Schott Solar - PROPOSED TRACT D  
(Mesa del Sol, Innovation Park II)

Jeff,  
I have finished reviewing the DRAFT Schott plans. Comments will be listed per sheet:

Re: Schott Solar Phase 1 Grading and Drainage Plan

Re: Schott Solar Phase 1 Grading and Drainage Plan Comments

DRAINAGE MANAGEMENT PLAN

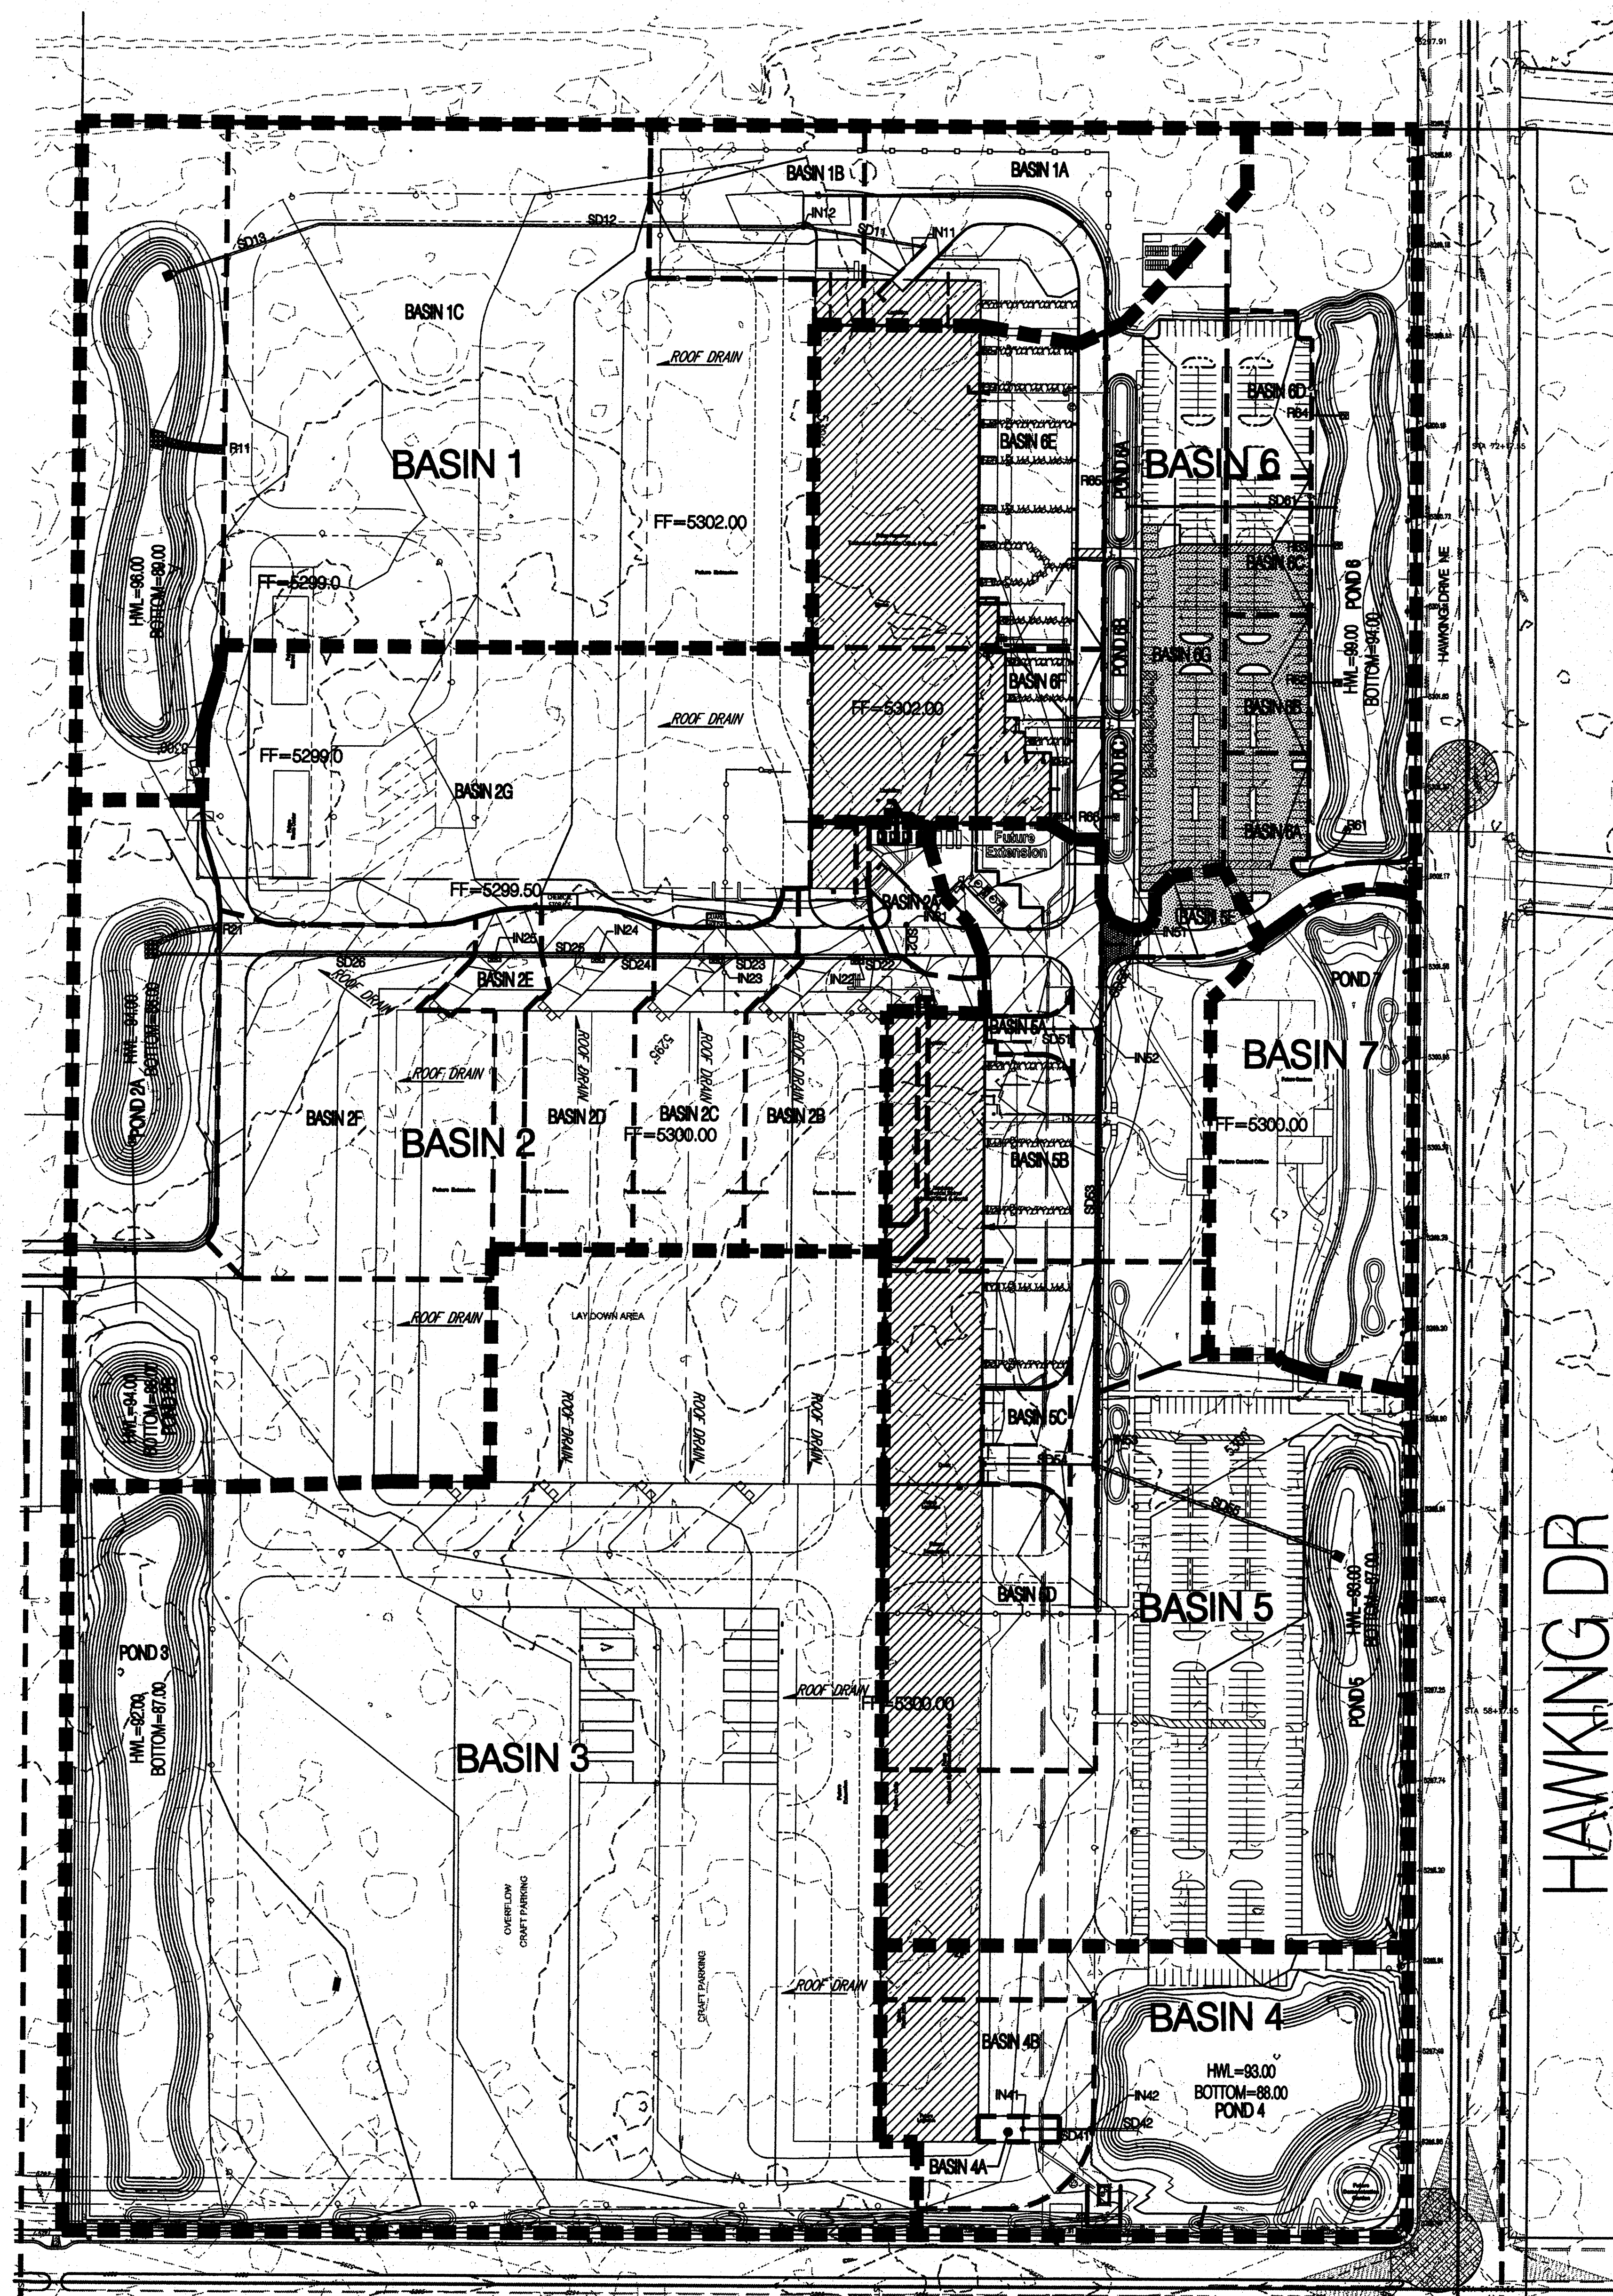
In the inlet table in sheet DMP-Overall, Basin 1 has two inlets not just the one listed.

- *In the inlet table in sheet DMP-Overall, Basin 1 has two inlets not just the one listed.*  
The additional inlet has been noted on the plan and added to the calculations.

2 RIP RAP BLANKET DETAIL
N.T.S.

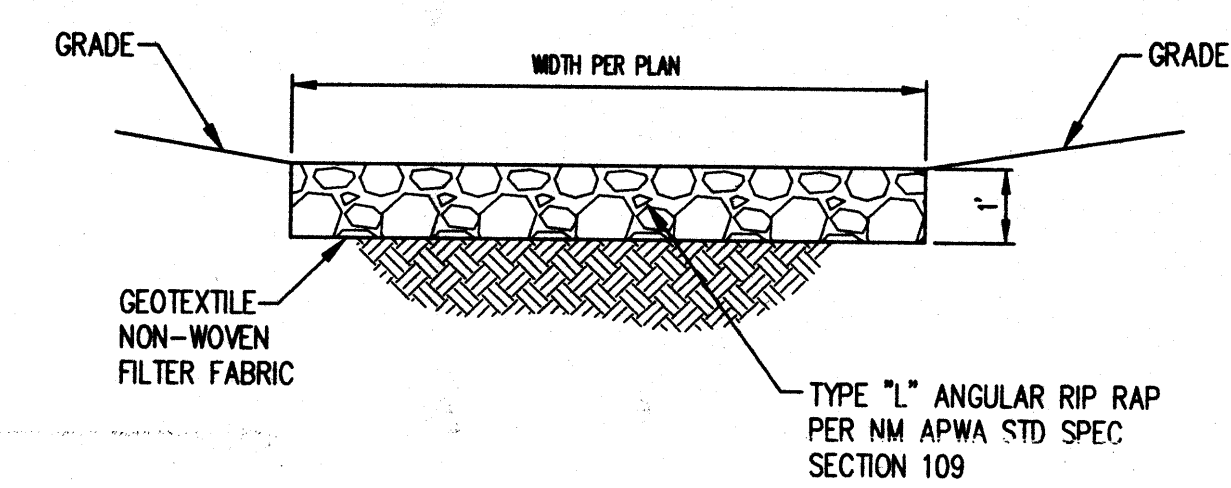
102:  
Detail 2 has an "x" for the depth of rip-rap.

- *Detail 2 has an "x" for the depth of rip-rap.*  
This has been changed to 8".

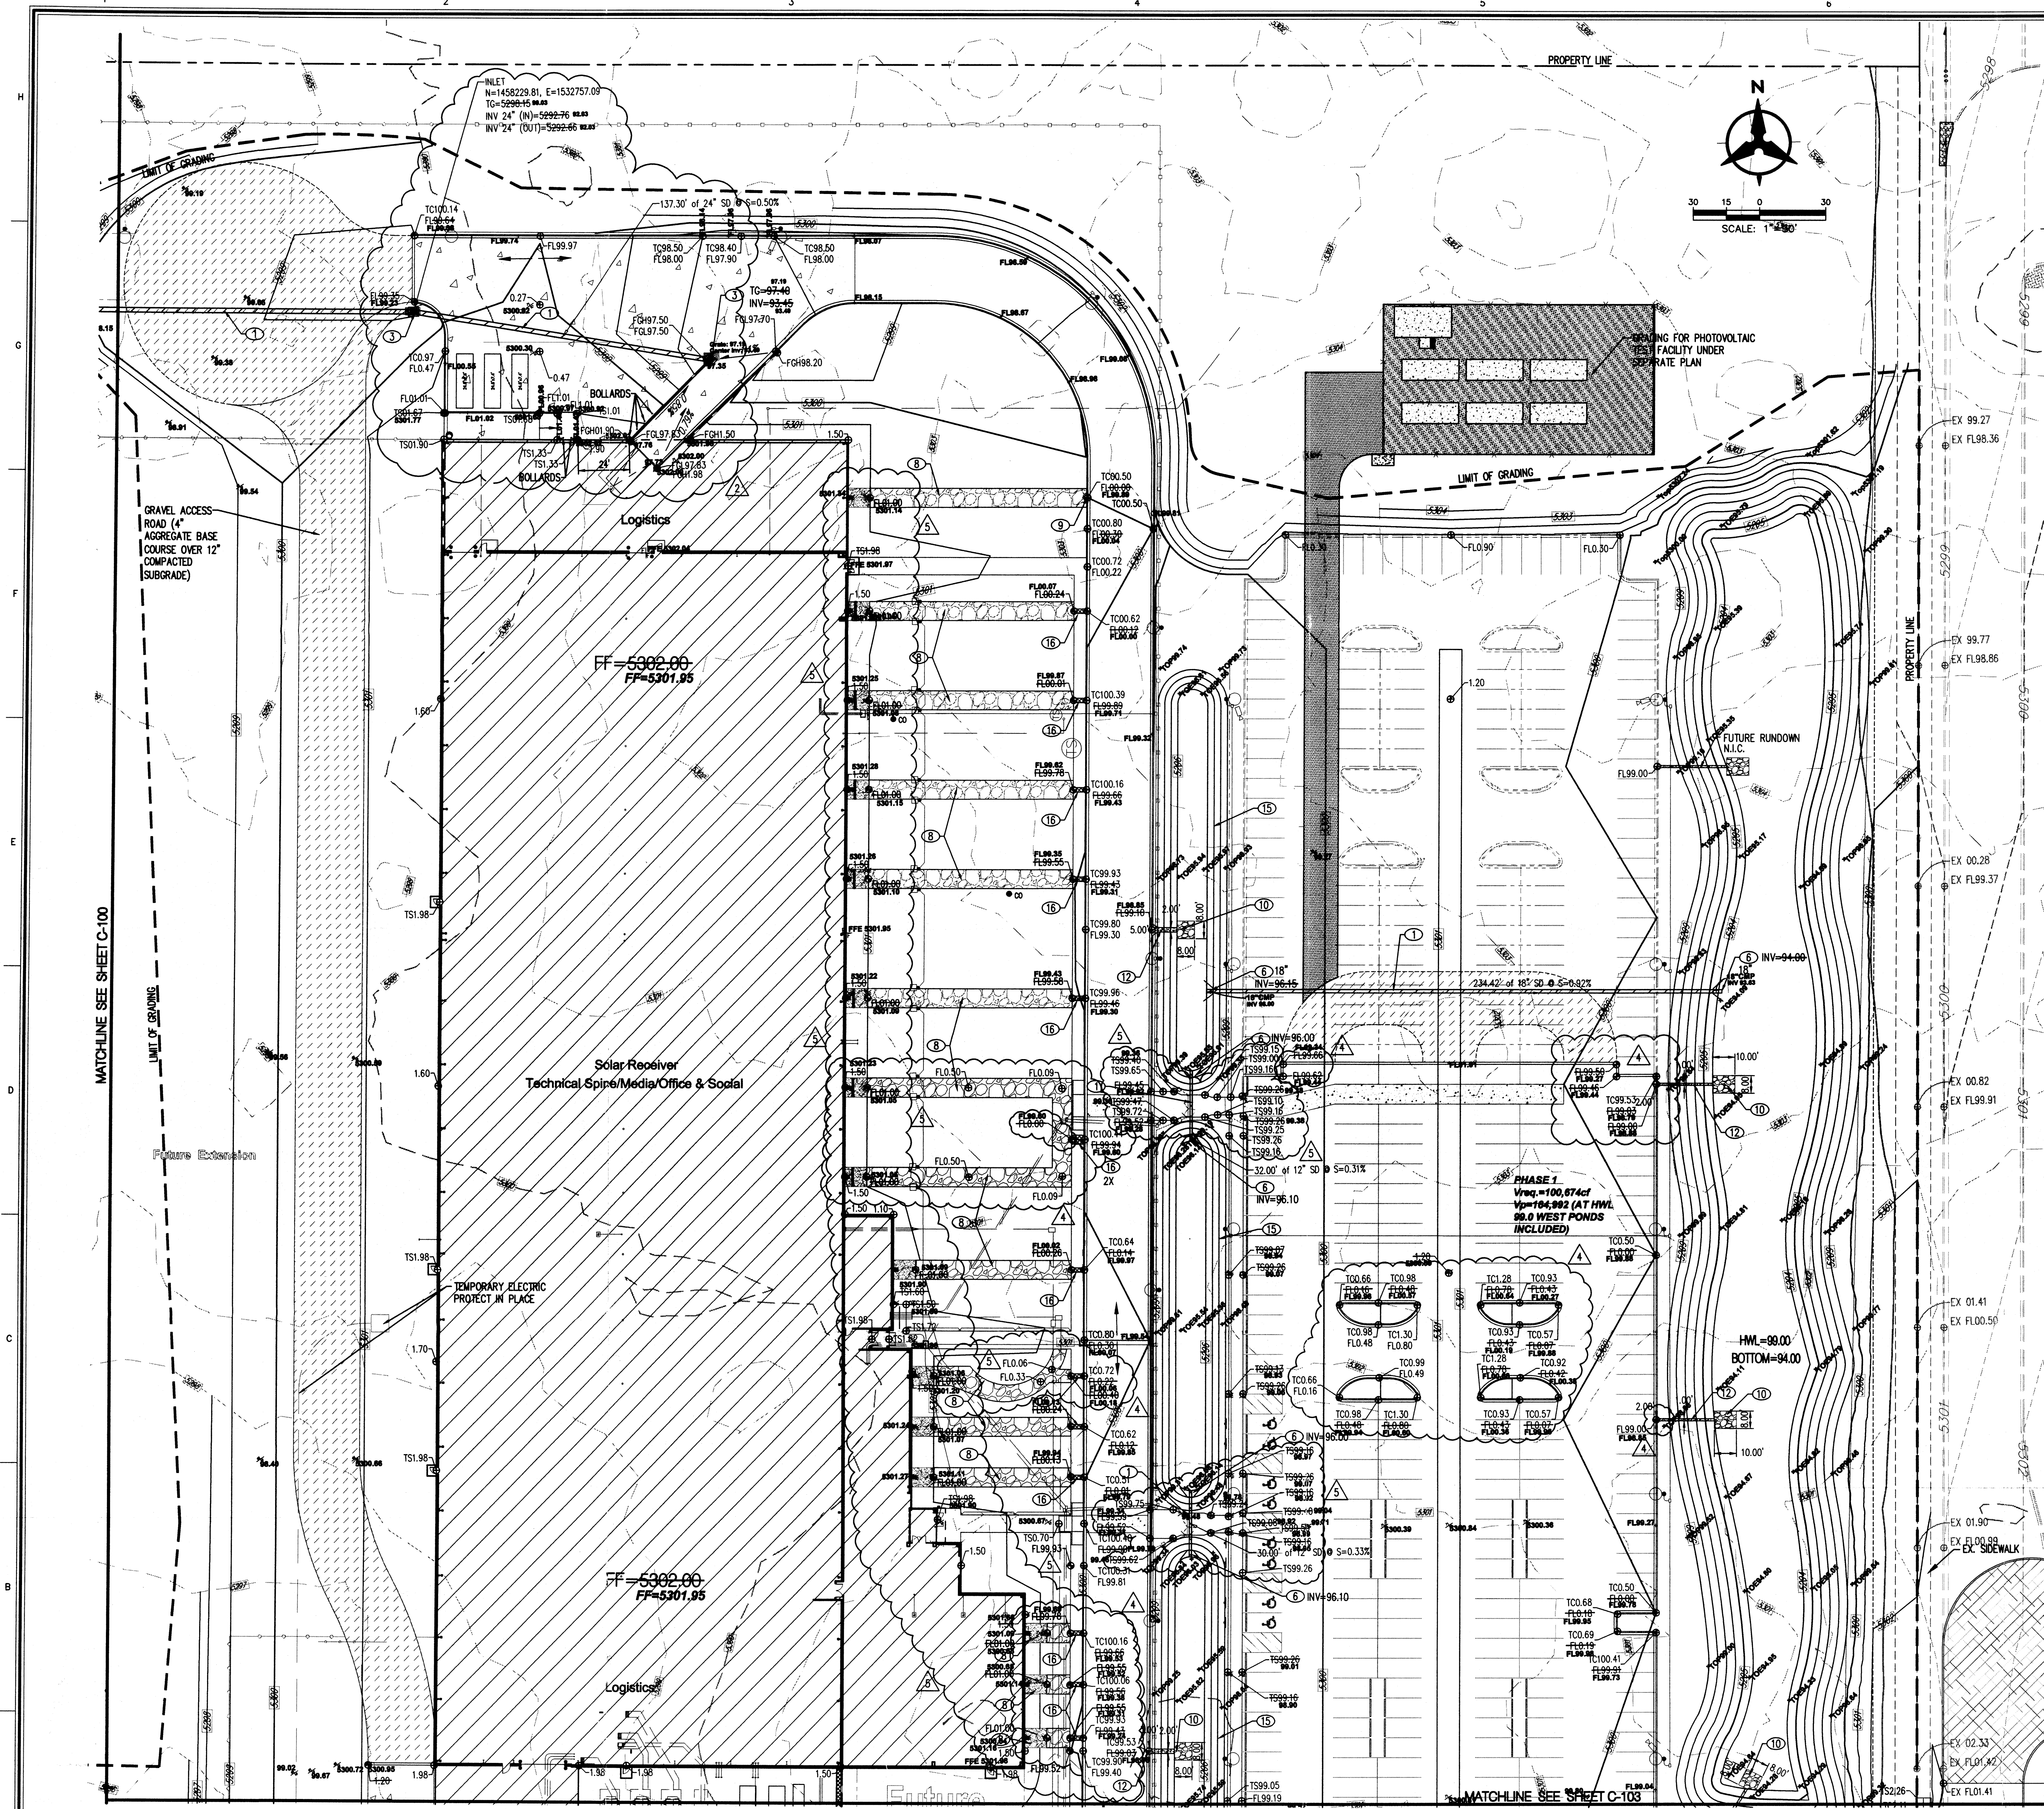
101:  
There is a Note 5 on the furthest north rip rap cobble swale. Why aren't you using a sidewalk culvert like the other ones?

There is a Note 6 at the end of the rundown in the furthest north little pond. I figure you don't want a cmp end section on a rundown.

Do you want the "12'" note near a Note 6. Seems out of place.

Provide a pond hydrograph for the little ponds east of the building. If they over-top, the water is heading south.

Sheet 101:

- ✓ • *There is a Note 5 on the furthest north rip rap cobble swale. Why aren't you using a sidewalk culvert like the other ones?*  
The sidewalk does not extend this far north.
- ✓ • *There is a Note 6 at the end of the rundown in the furthest north little pond. I figure you don't want a cmp end section on a rundown.*  
This has been changed to Note 10, Rip Rap Blanket.
- ✓ • *Do you want the "12"" note near a Note 6. Seems out of place.*  
Yes, this refers to a 12" end section.
- ✓ • *Provide a pond hydrograph for the little ponds east of the building. If they over-top, the water is heading south.*  
This situation has been analyzed and revised. The pipe draining the small ponds has been resized to an 18". The AHYMO analysis is attached.
